Kirklees Council, Planning and Development Service, Huddersfield, HD19EL

Re: Proposed house extension Ref: 2024/91300.
30 Dorchester Road Huddersfield, HD22JZ.

Drawing
Proposed Site Plan

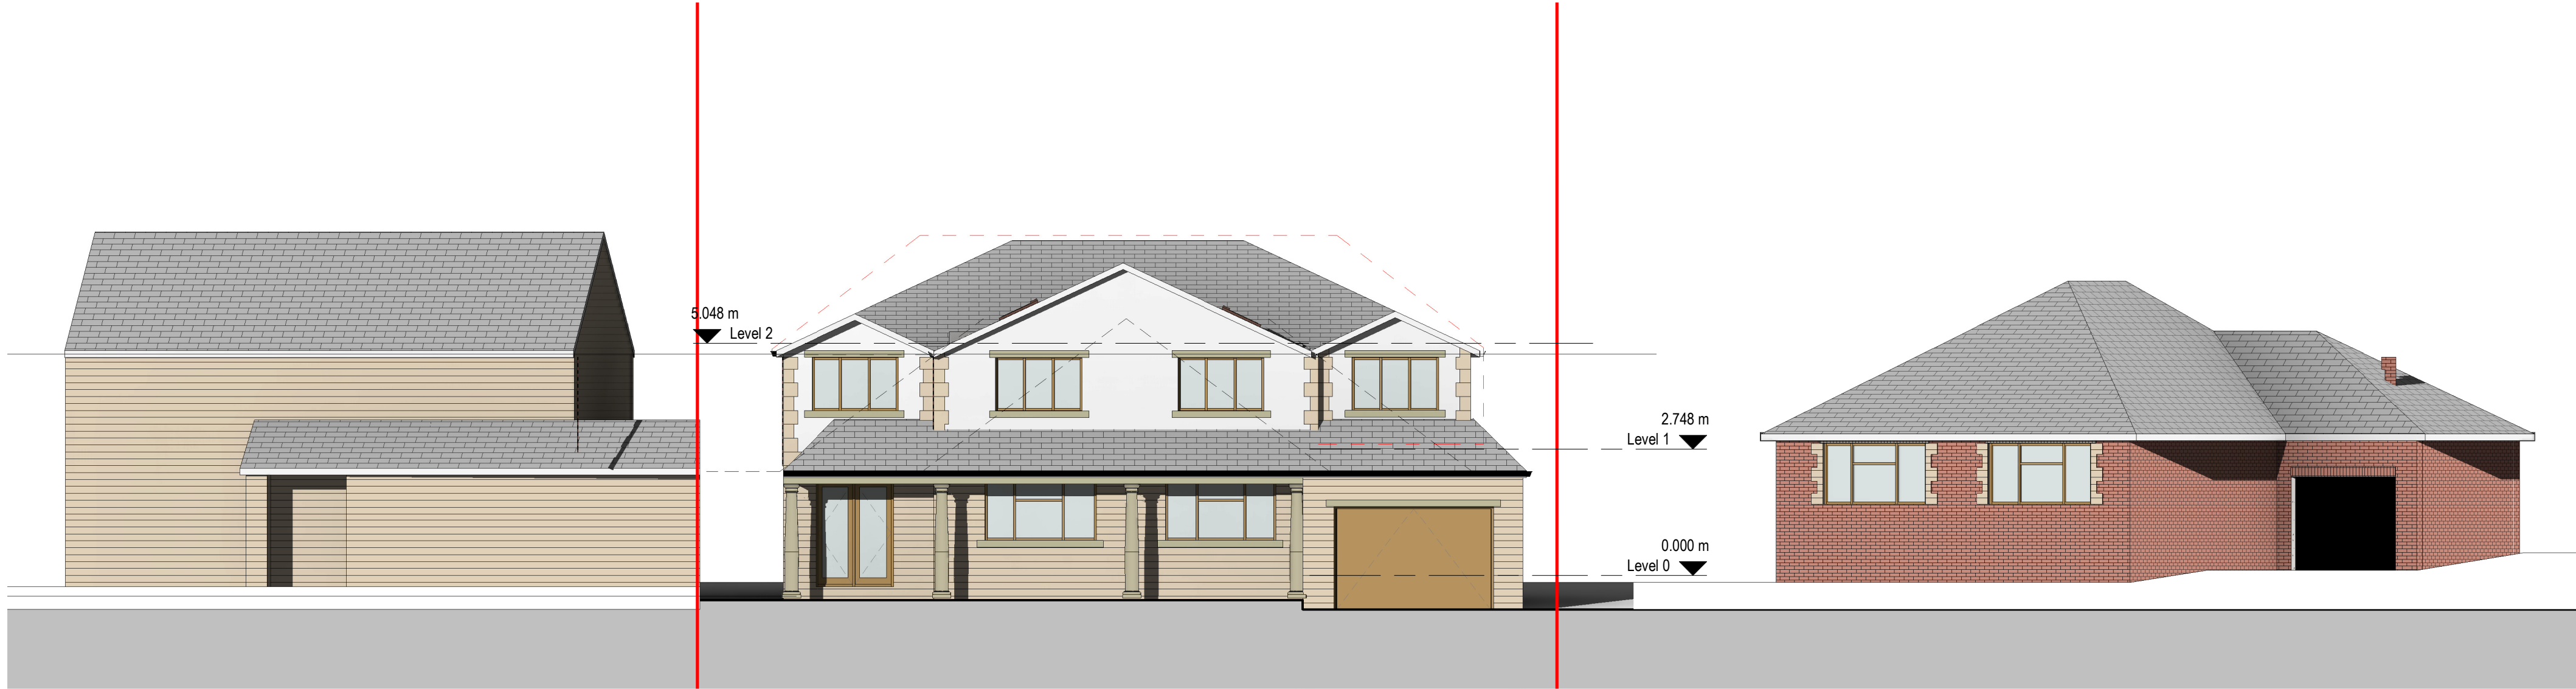
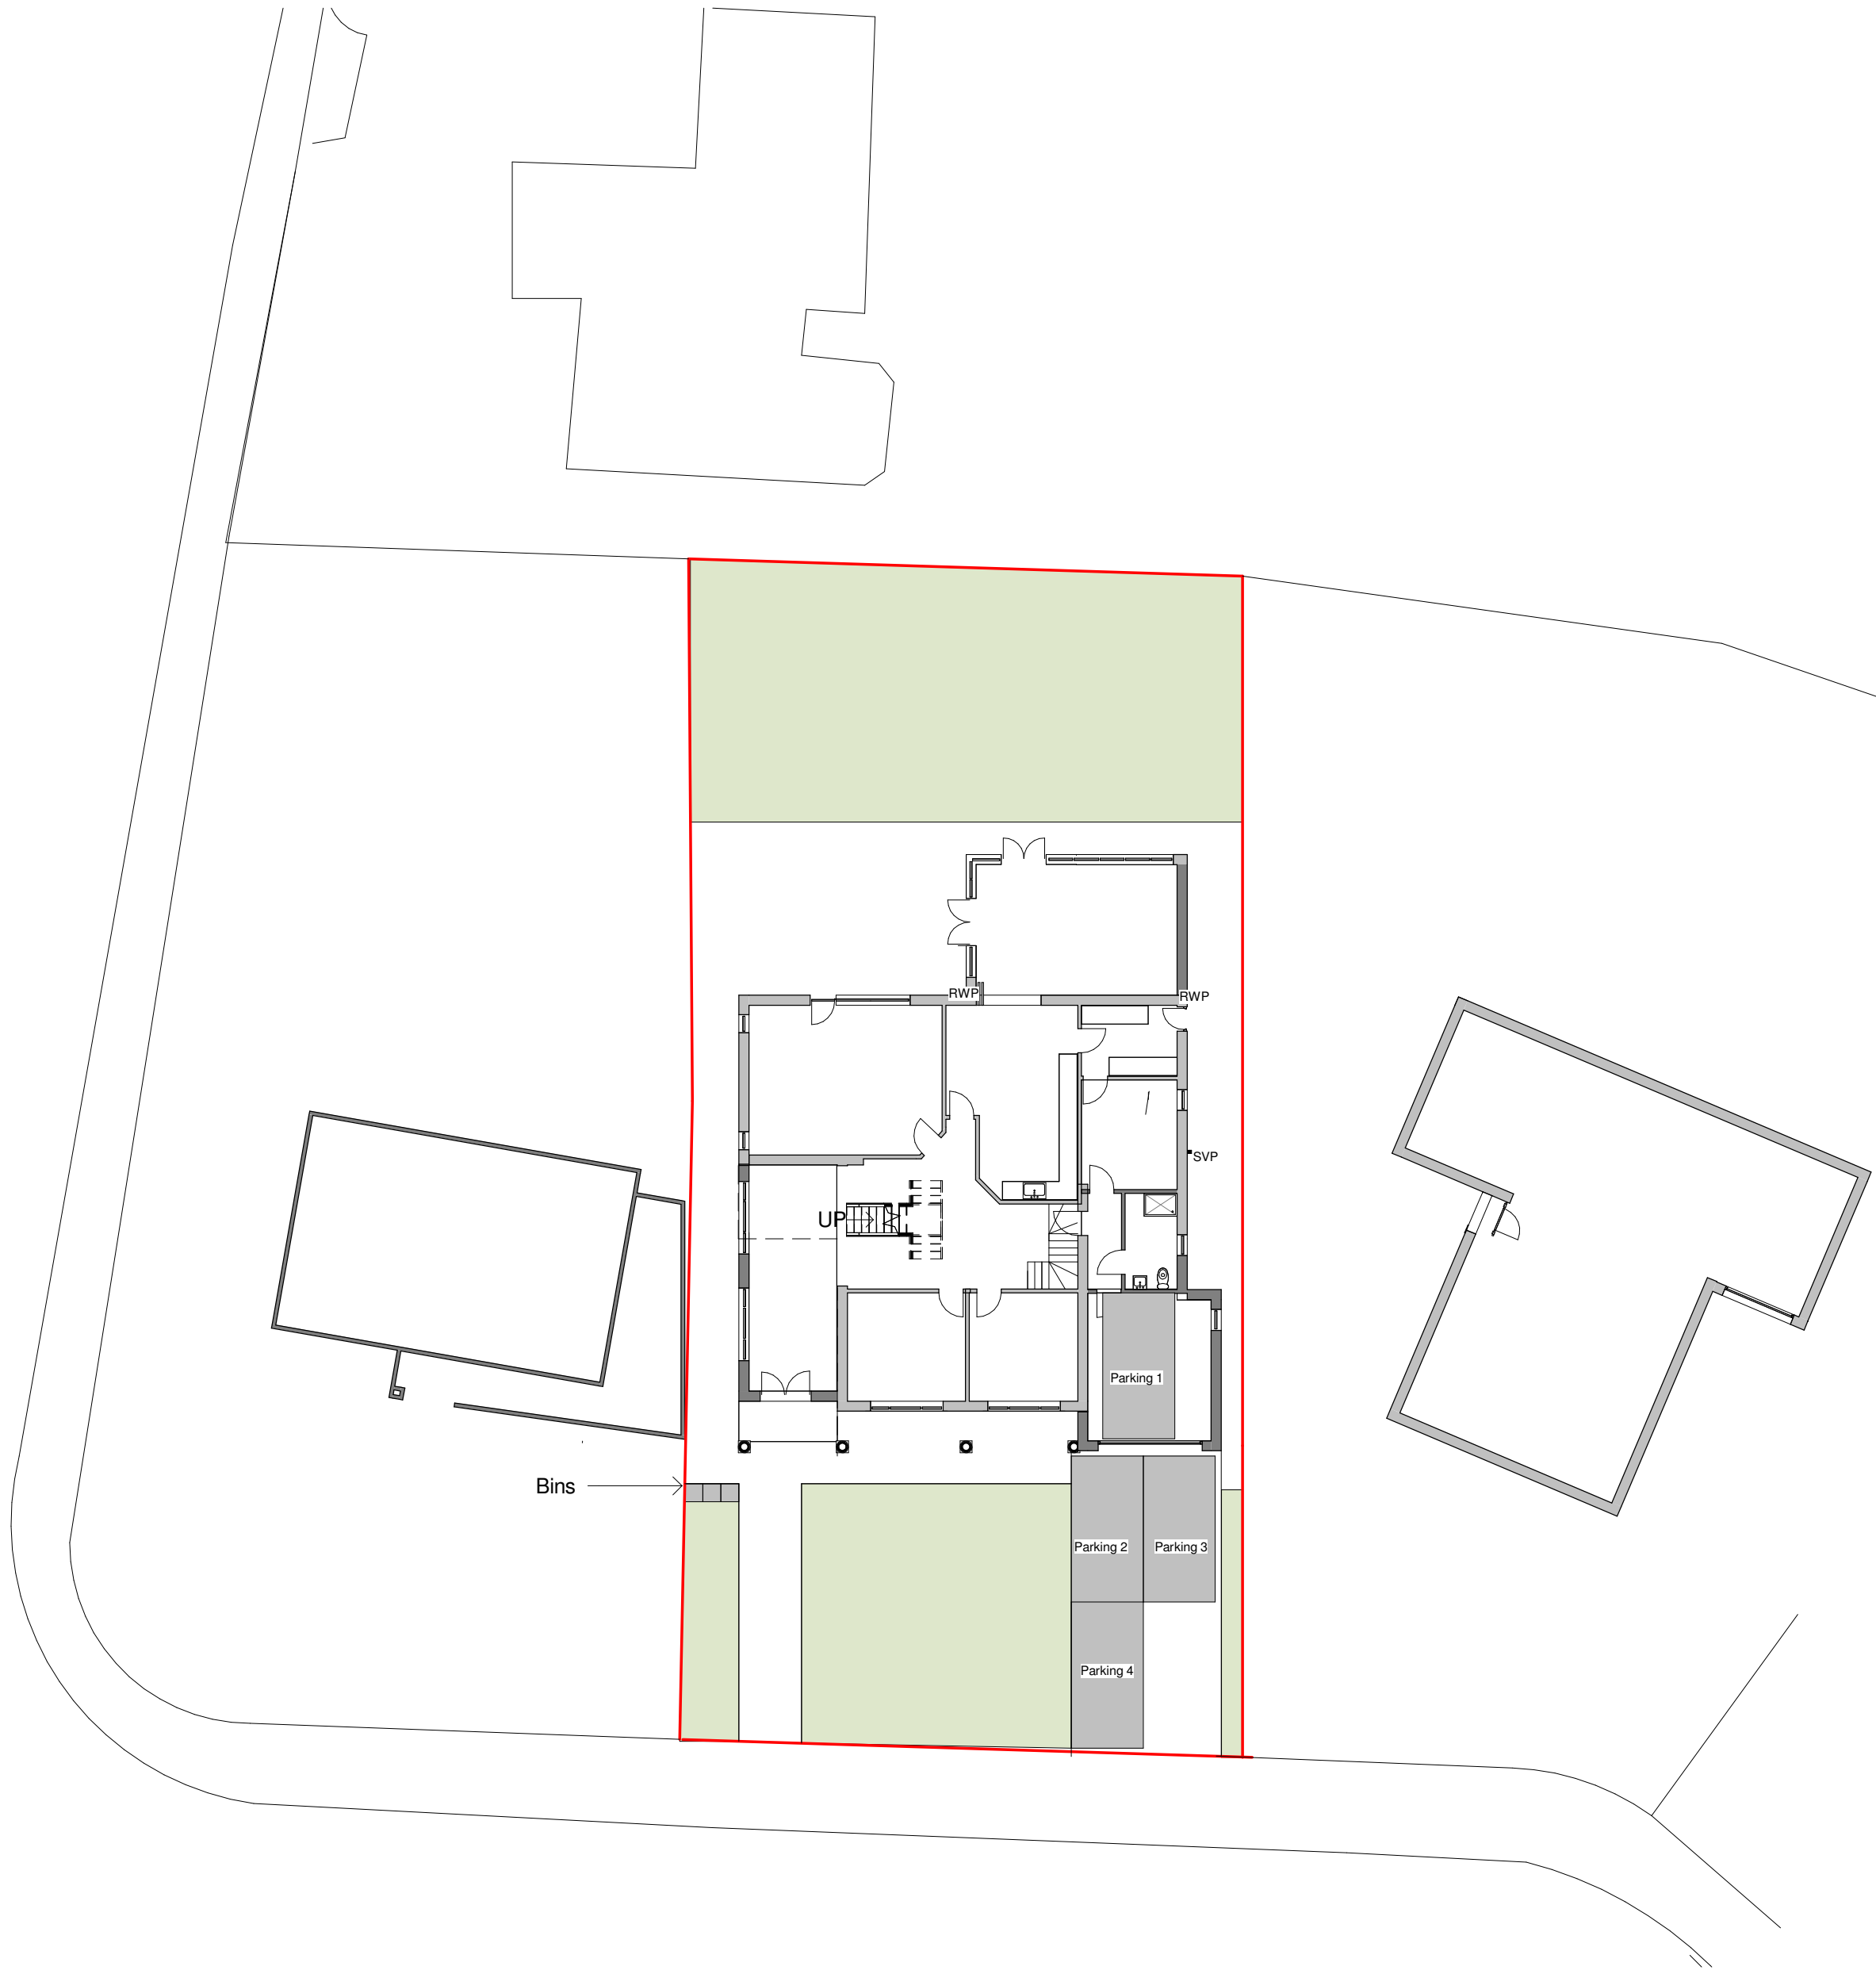
- Light:
The proposed new extension alters the impact that the house will have on us dramatically, from a single story with pitched roof to a full two storey house. We feel that this could impact on the light we have in our house and garden.
Have you carried out a site inspection and calculations for this situation?
If so, could you please let us have the calculation and relevant building regulations?.
- Parking:
The proposed extension as seven bedrooms which would indicate a high likelihood of quite a few people living/visiting the property with the associated parking of many vehicles.
The proposed drawings allow for two cars maximum in the drive and possibly one in the new garage. Is this sufficient for a house of this size?

Drawing
Proposed Side Elevation

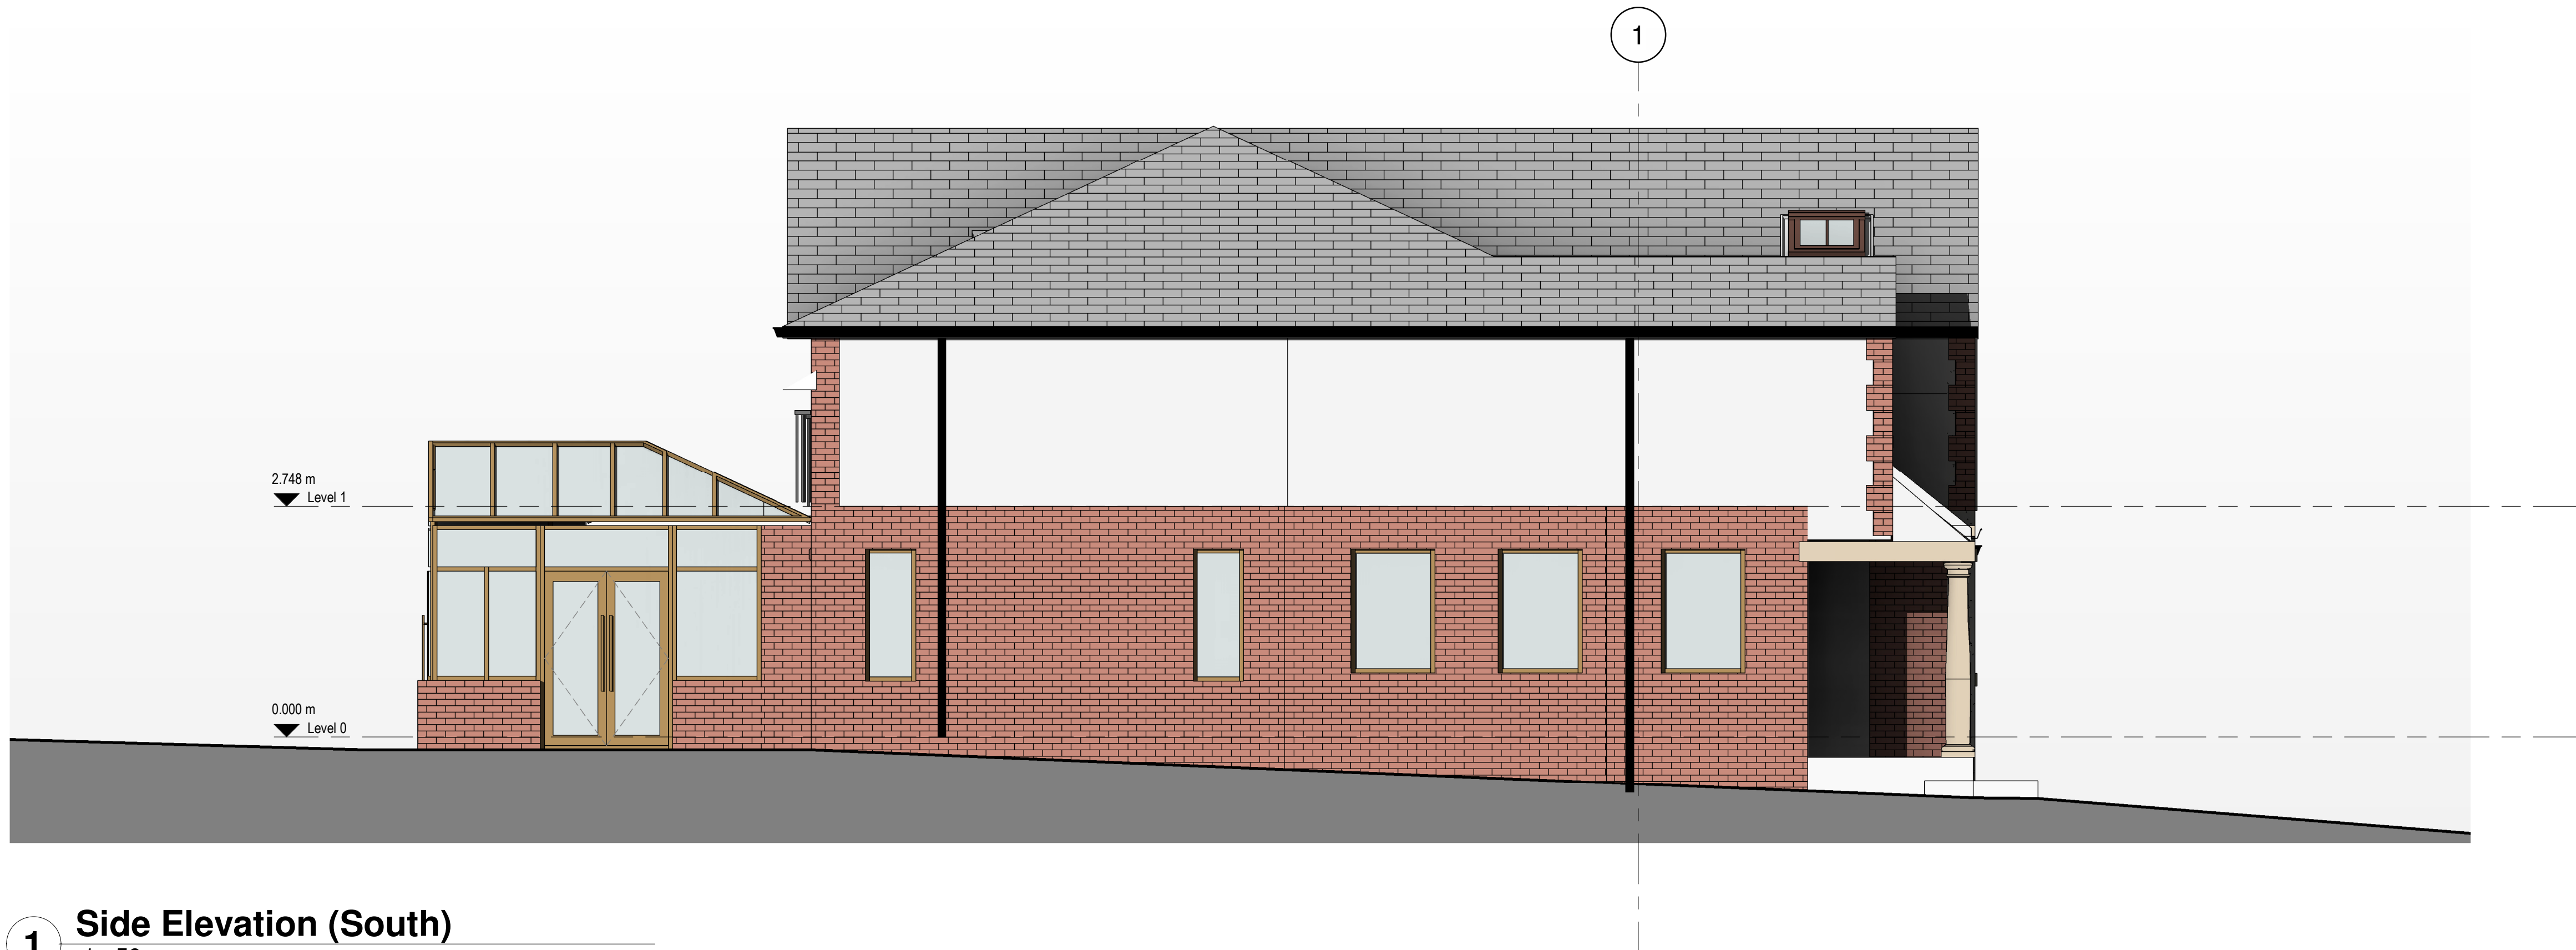
At present the original house has only one window at 1st floor level (located on the staircase) which has opaque glass fitted.

The proposed new extension layout as three windows shown on the building layout drawings. All these windows face our house. I am sure that you are aware that our house is a bungalow and the proposed 1st floor windows look directly down into our bedroom and lounge!

Having looked around at our surrounding neighbours houses none of the side elevations facing other properties have 1st floor windows fitted.

Could you let me know if this is now acceptable practice, having high level windows facing living and sleeping areas of our home.
